MARINE RESTORATION & CONSTRUCTION LLC

March 27, 2023

Re: ***Myre Boatlift Repair, Permit #SHL23-023 Review Letter; 6215 77th Ave SE***

EXISTING ELEVATION VIEW

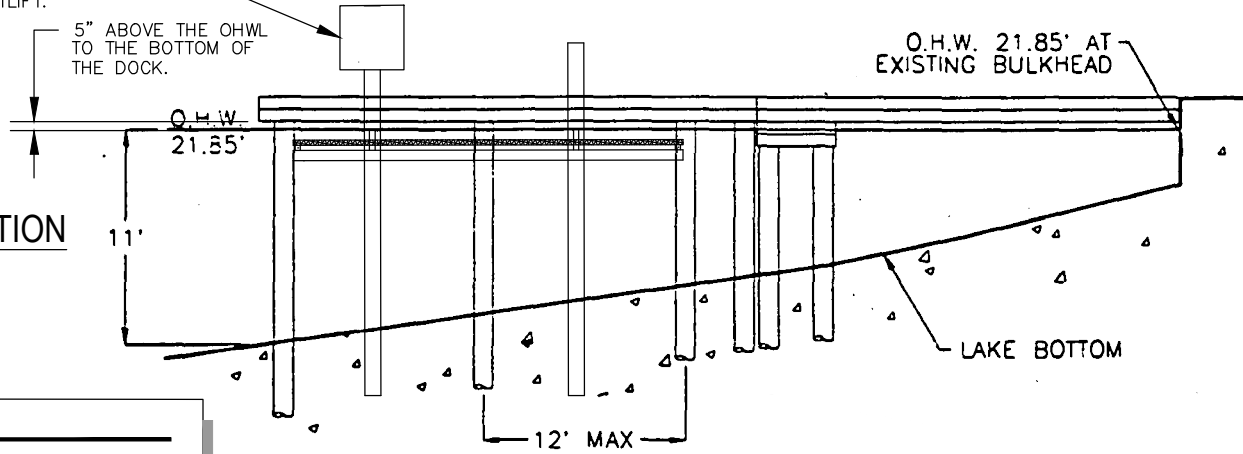
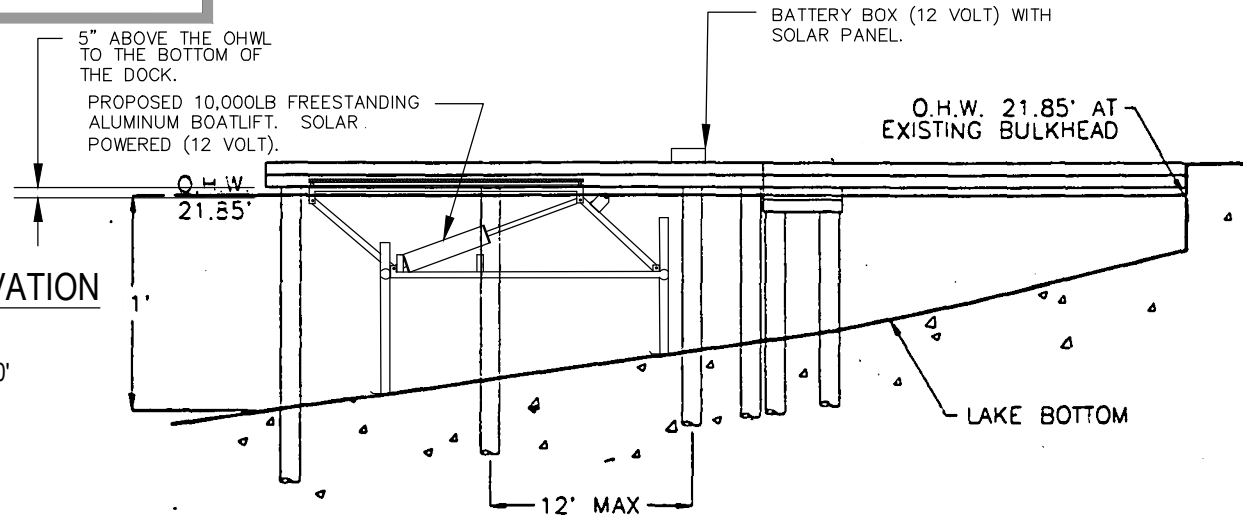
3. Further show how the proposed work is maintenance and repair.

We are requesting a Shoreline Exemption. The project is being proposed as an exemption as maintenance and repair. The lift is old and in need of complete repair. It is also a galvanized lift that is to be replaced by an aluminum lift. Galvanized lifts are no longer allowed and are considered harmful to the environment.

The method of repair of the lift and removal of the galvanization is replacement.
